Applicant: Bloxham School

Proposal: Extension of existing boarding house through the reinstatement of part of the existing ruined coach house, the demolition of outbuildings, the erection of an extension and link structure (with associated alterations to Stone Hill House), insertion of internal wall, and associated works

PROPOSED SOUTH ELEVATION
1: 100 @ A1

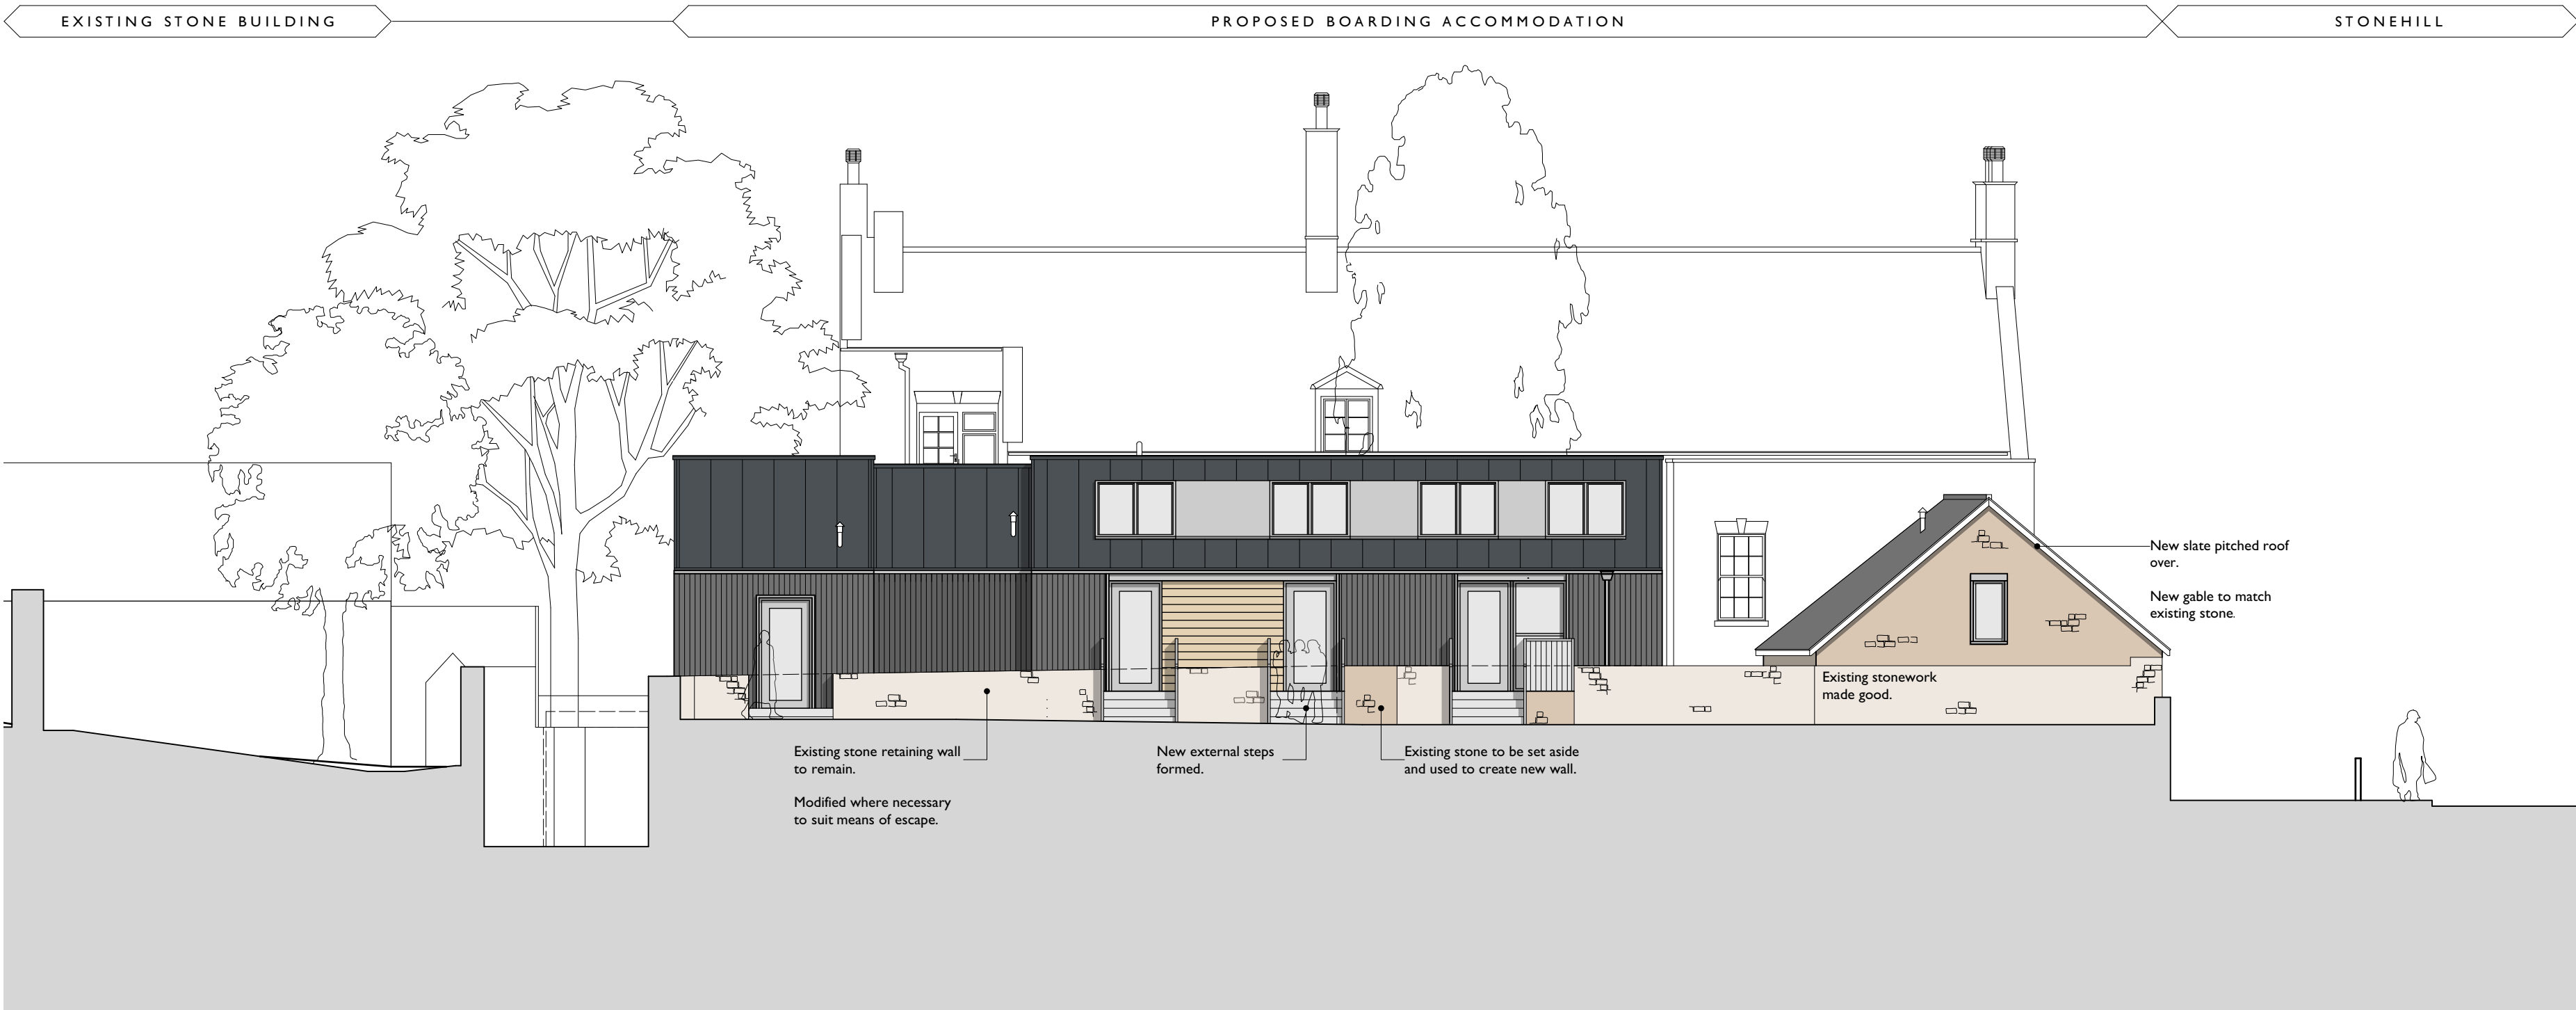
- Revision to the proposed roof material of the reinstated coach house. This would now feature a slate finish, rather than a standing seam zinc finish.
- Revised window to the first floor on the eastern elevation (the revised window design is slightly inset to the elevation, rather than the extruded style of window originally proposed).
- Retention of a greater proportion of boundary wall to Old Park Farm Annexe.
- Reduction to the stepped terrace area (this now solely relates to areas of emergency access requirements).
- Adjustment to the southern elevation of the coach house, to reduce the extent of glazing within the opening facing the street scene.

8.14. The reduction in the building's height has been largely or entirely achieved through an asymmetrical roof design, which is not a typical design feature in this part of the Bloxham. Nonetheless, it is considered that the reduction in height of the ridge would limit the impact of the roof to a potential glimpse from the public highway as from either side of the extension the only view would be of the roof slope. The use of zinc standing seam for the roof of the extension is considered acceptable and not in conflict with Policy ESD 15.
